From: Simon Davis
Sent: 03 October 2018 12:56
To: 'Phil Hamblin'
Cc: Richard Brooks
Subject: RE: BR/143/18/Change of use from vacant arcade

From: Simon Davis
Sent: 02 October 2018 14:51
To: 'Phil Hamblin'
Subject: RE: BR/143/18/PLChange of use from vacant arcade

DRAWING TITLE	
Existing plans & Elevations incl. Site Location Plan	
DESIGNED BY	PH
DRAWN BY	Apr 18
SCALE	1:100, 1250

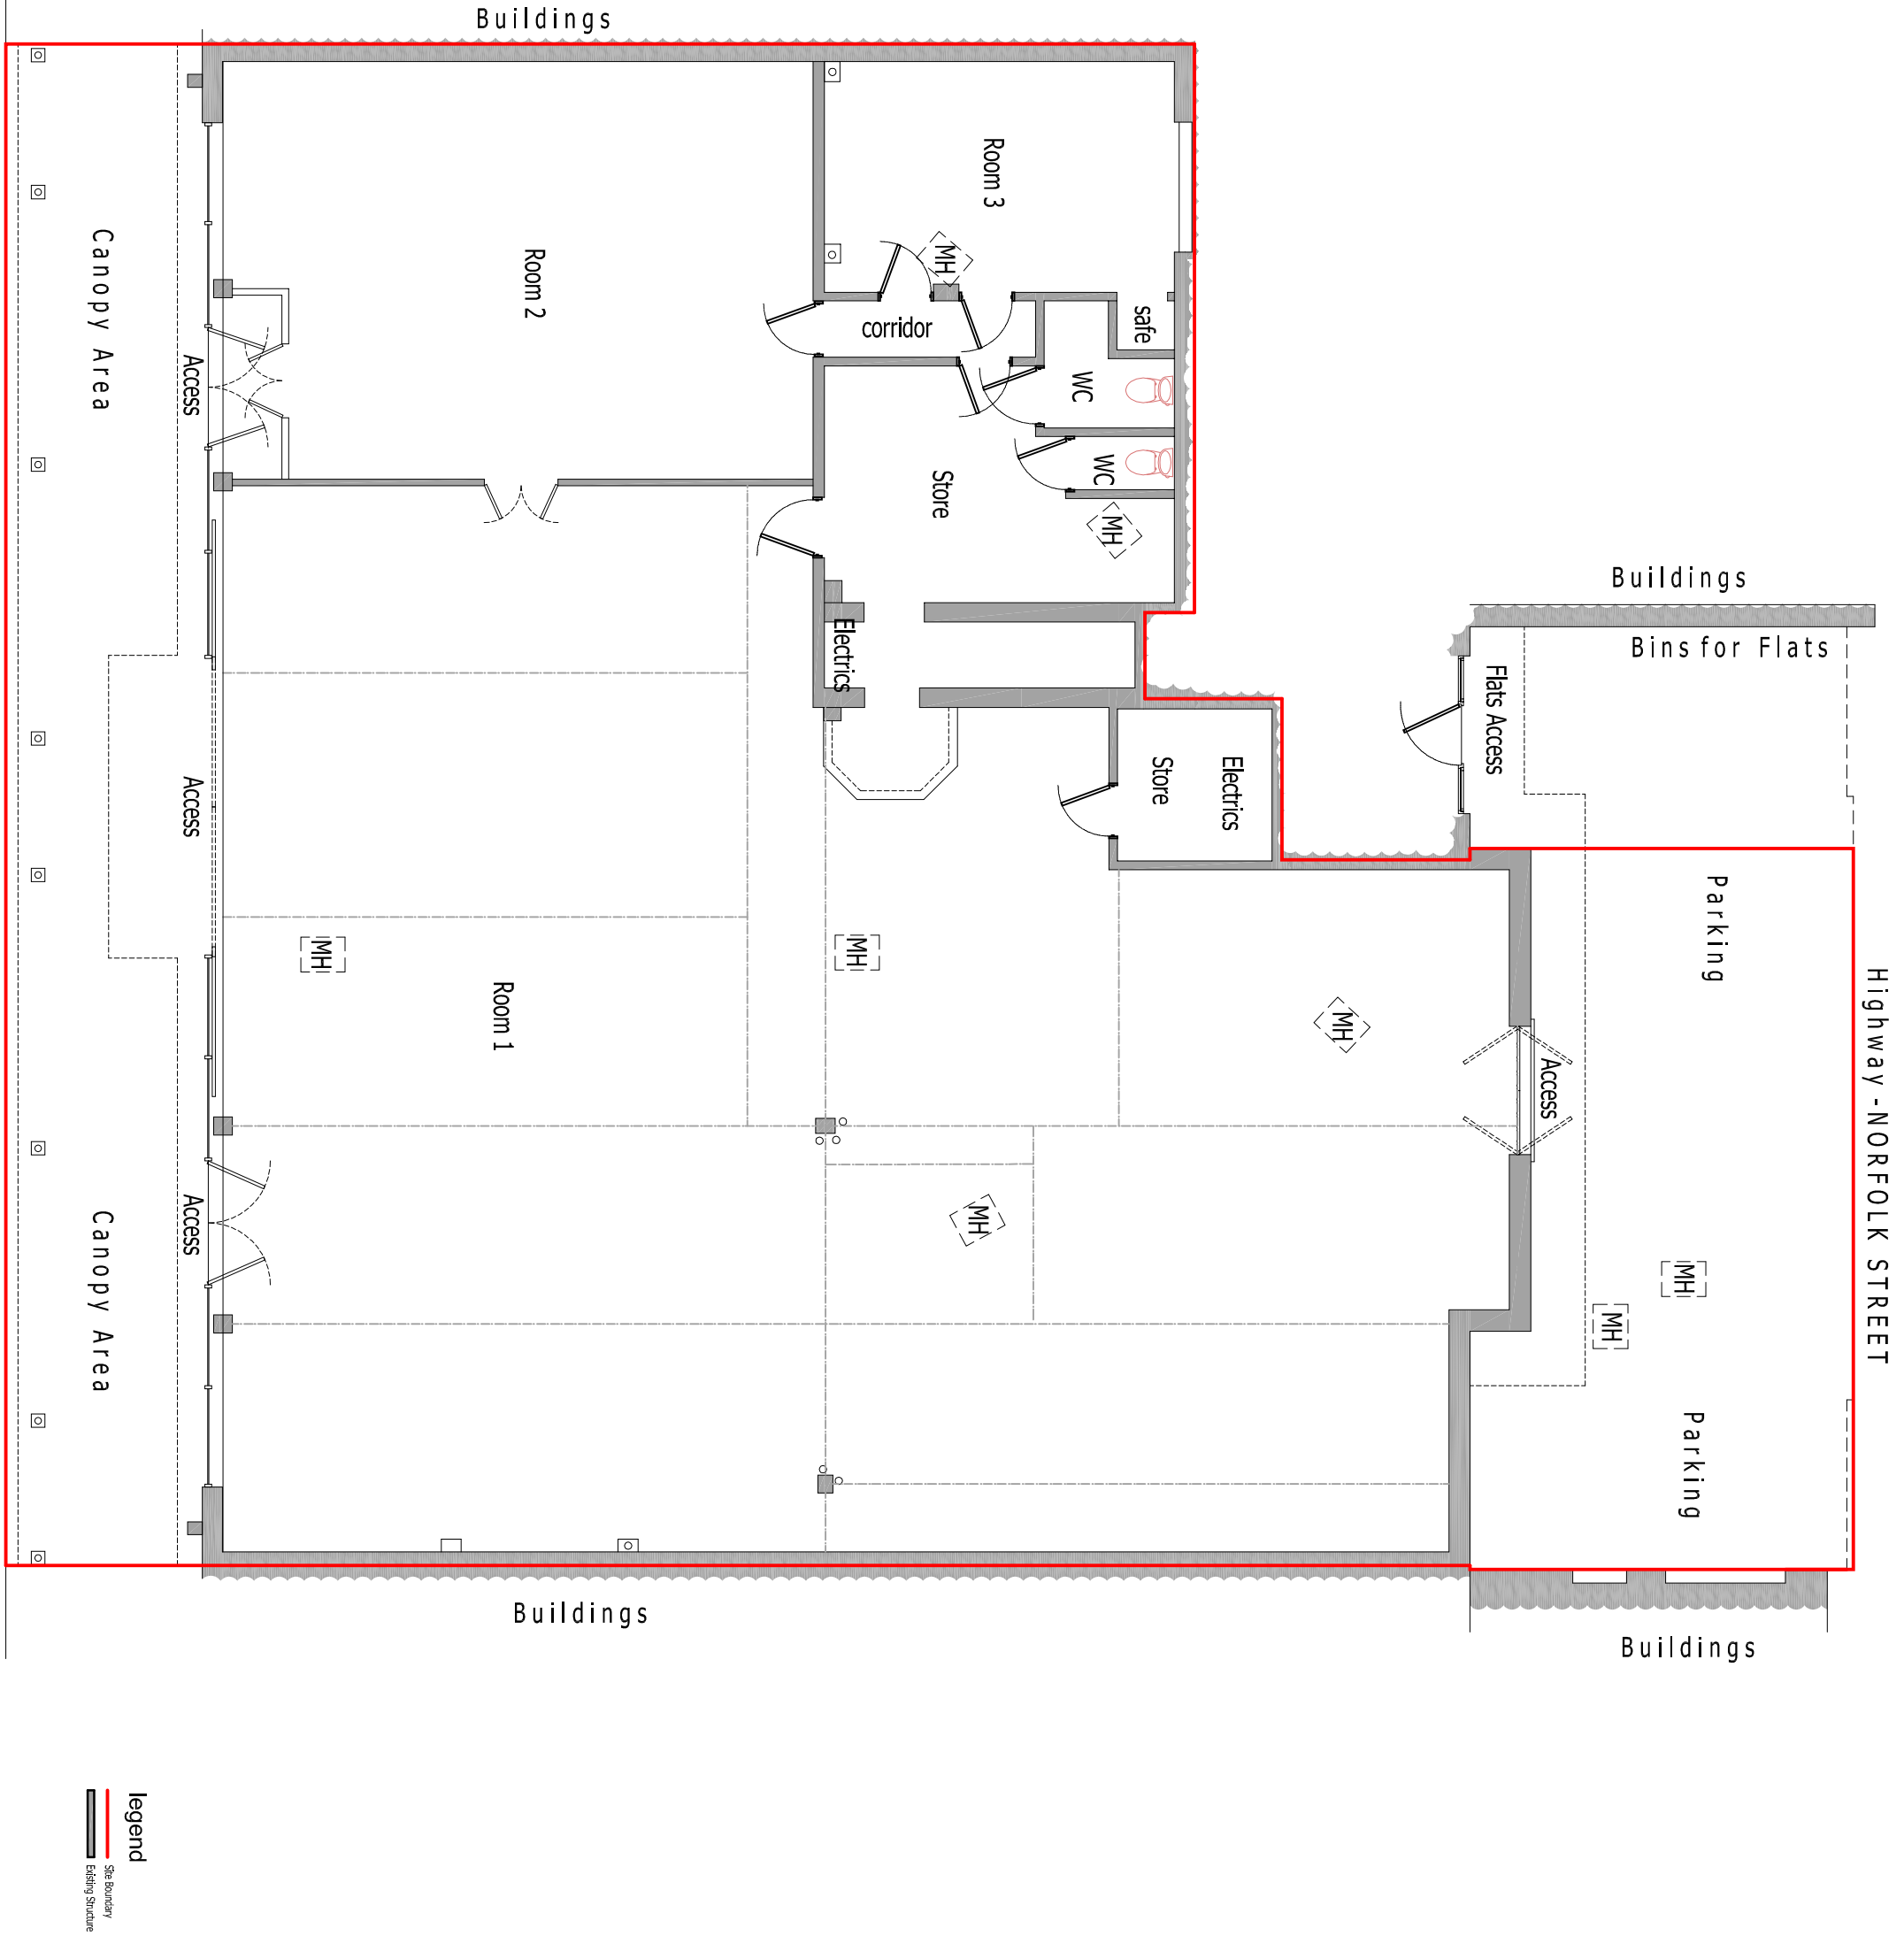
Can you confirm what is happening with the existing parking at the rear. I counted about 5 off-street spaces on Norfolk Street when I visited. The plan suggest these will be removed and replaced by the bollarded hardstanding area on which the bin store partially sits. Also, can you advise who these parking spaces were for. Thanks.
